# CITY OF ALBUQUERQUE

**Re: 806 Old Coors Blvd SW,  
Request for Temporary Certificate of Occupancy - Not Approved  
Engineer's Stamp dated 07/20/10 (L-11/D066)  
Certification dated 11-03-11**

PROJECT: 806 OLD COORS S.E.C. OF OLD COORS AND GALLEGOS RD. S.W. ALBUQUERQUE, NEW MEXICO
DRAWN BY: DVA
JOB NO. 806
PROJECT MANAGER: STEPHEN DUNBAR, AIA
SHEET TITLE: SITE DRAINAGE PLAN

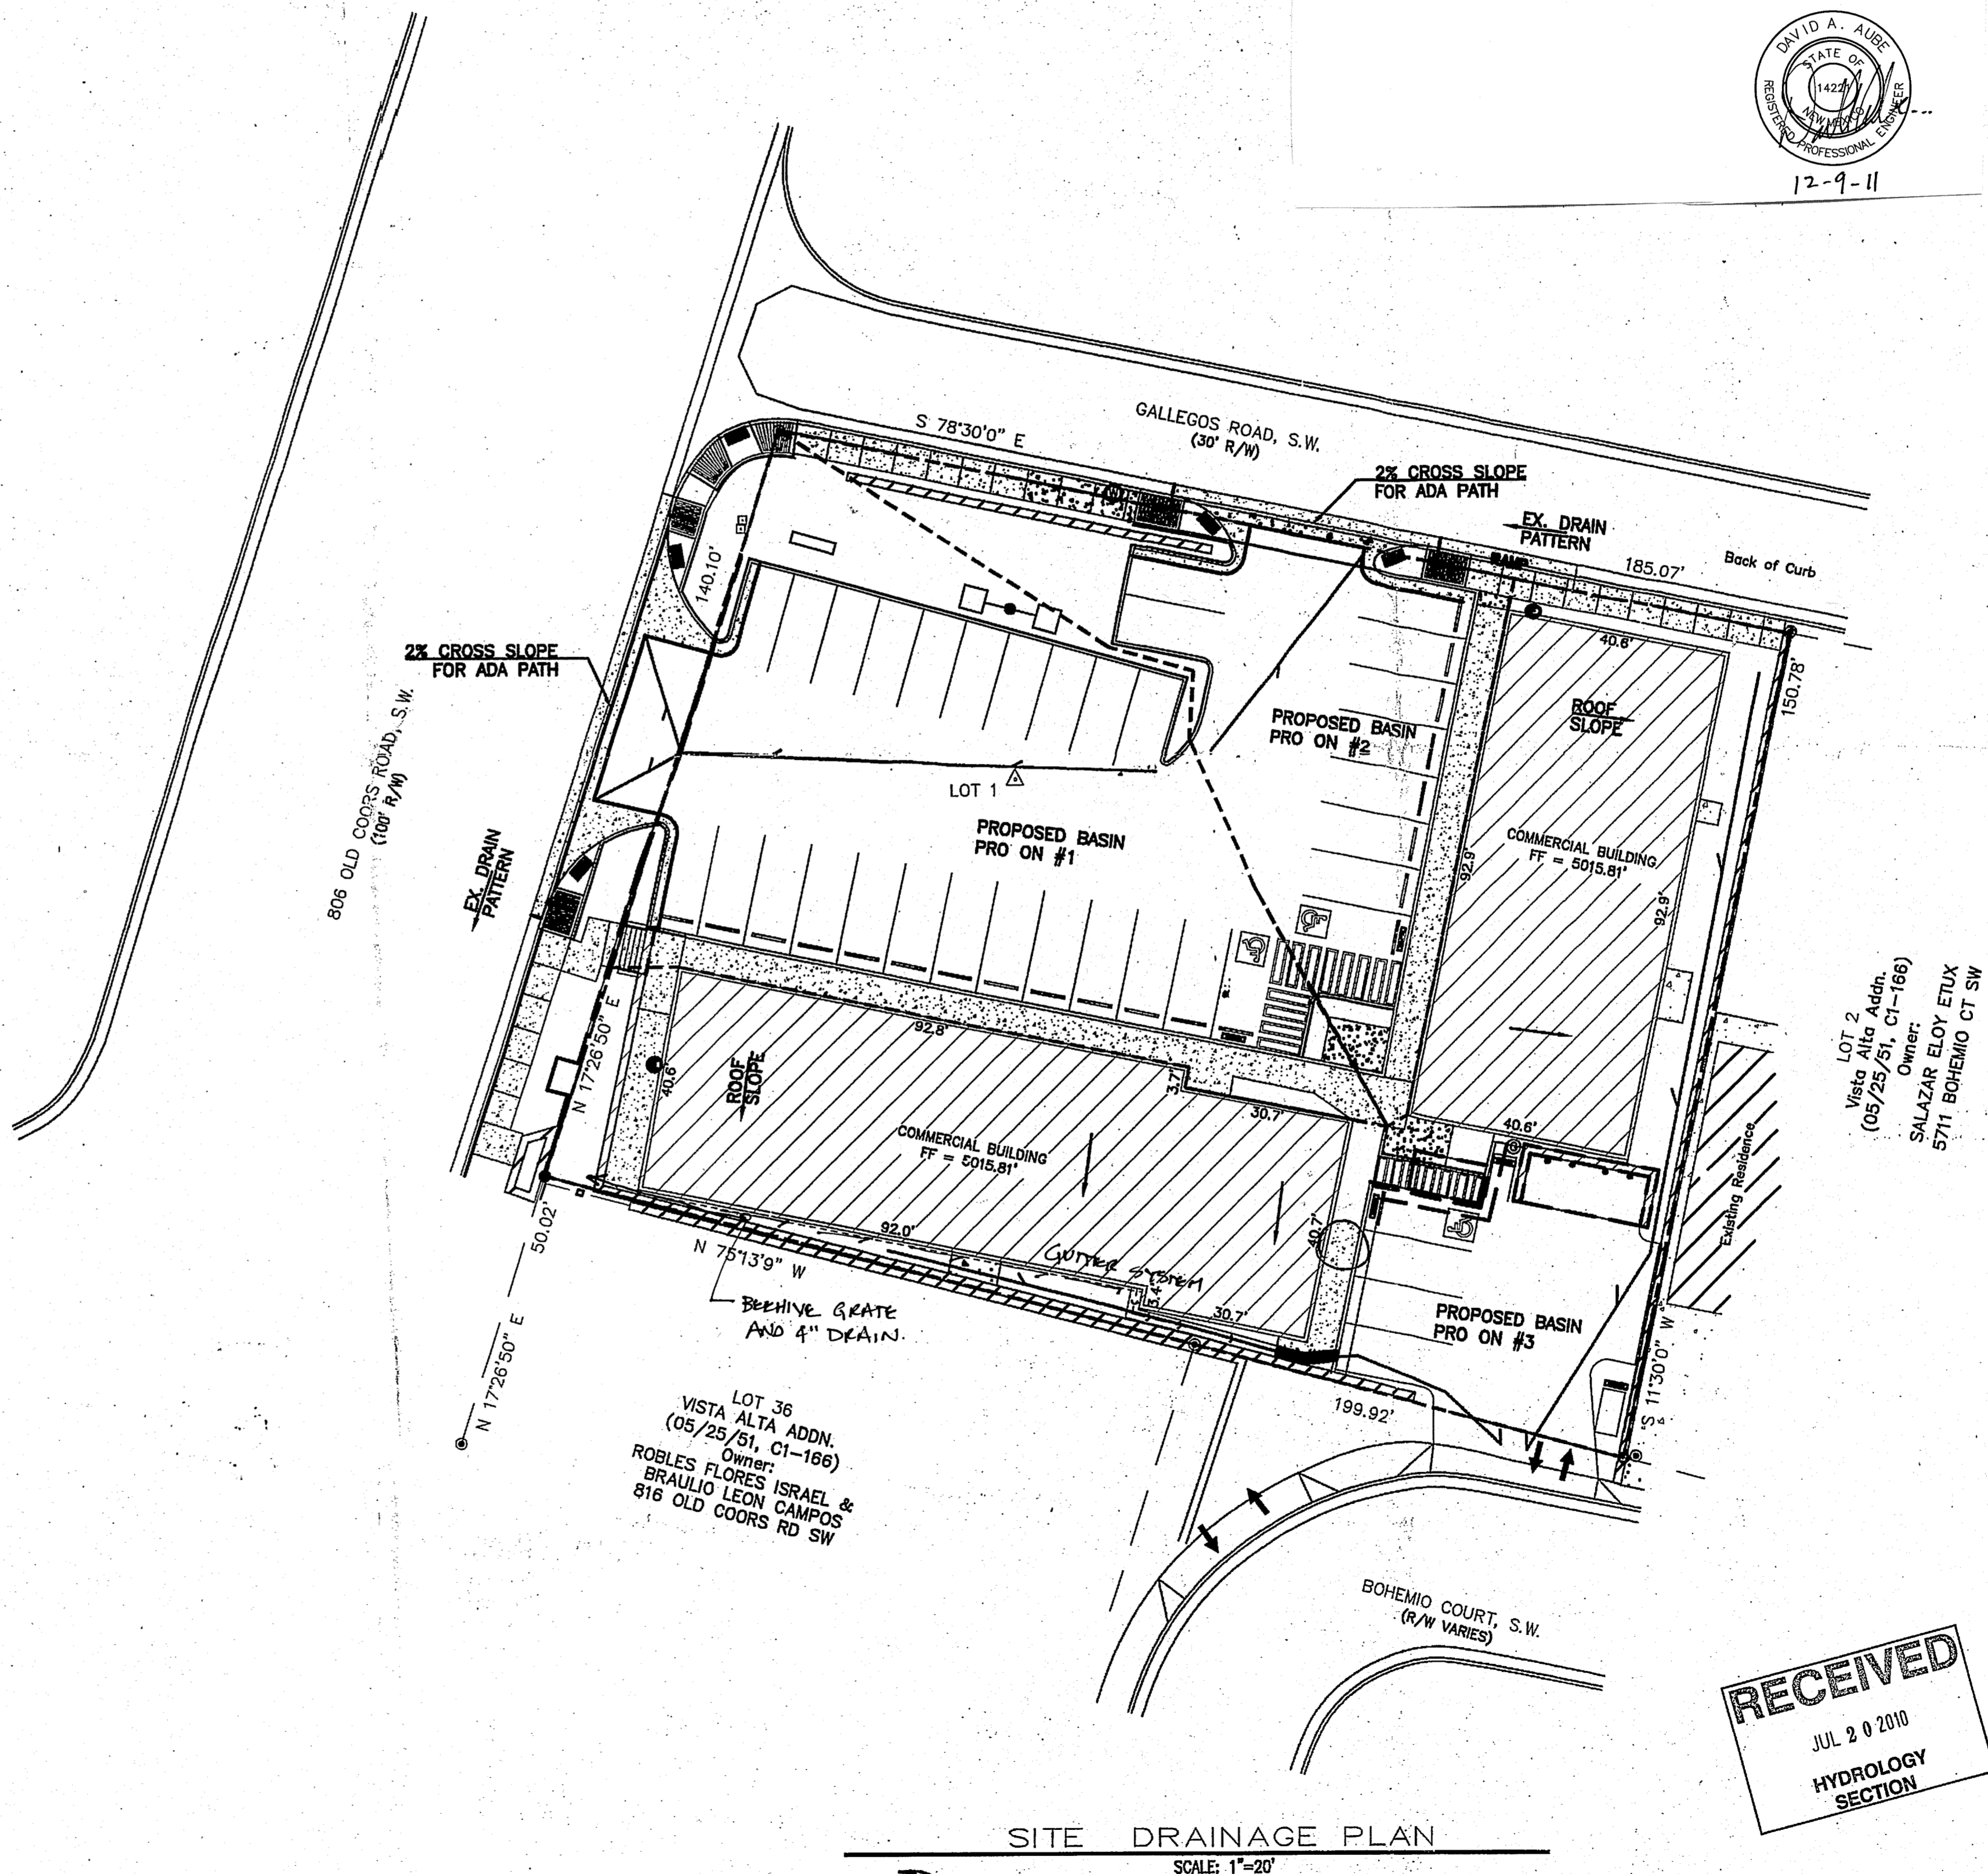
- The Engineer's Certification will need to be on all sheets being certified.
- The design intent does not appear to meet:
  - Certifications should reflect genuine site conditions.

- The approved plan shows some type of wall on the northwest area of the site between Old Coors and the driveway off of Gallegos. This was not constructed. Show as not built.

- The sidewalk along the eastern building, on the western side of this building, was designed to be ramped; stairs were constructed instead. Show on the plan stairs were constructed in lieu of a ramp.

- The landscaping area east of the eastern building appears to discharge to Gallegos Road. Per the approved plan this area should discharge to the south through the parking lot into Bohemio Court. Additional spot elevations will be required in this area. Will this building need gutters?

- The southern building will need additional survey on the south side to ensure adequate drainage.

- The area south of the south building should drain per the approved drainage plan.
- Show the double wall on the south side. Is one of these walls retaining? Did these walls exist? If so clarify on the plan.
- Could the roof be guttered? Additional work may be required in this area to mitigate the drainage issue in this area.
- Additional survey is needed for the sidewalk adjacent to the southern building along the west side.
- A scale and north arrow on sheet C2.1 is required.
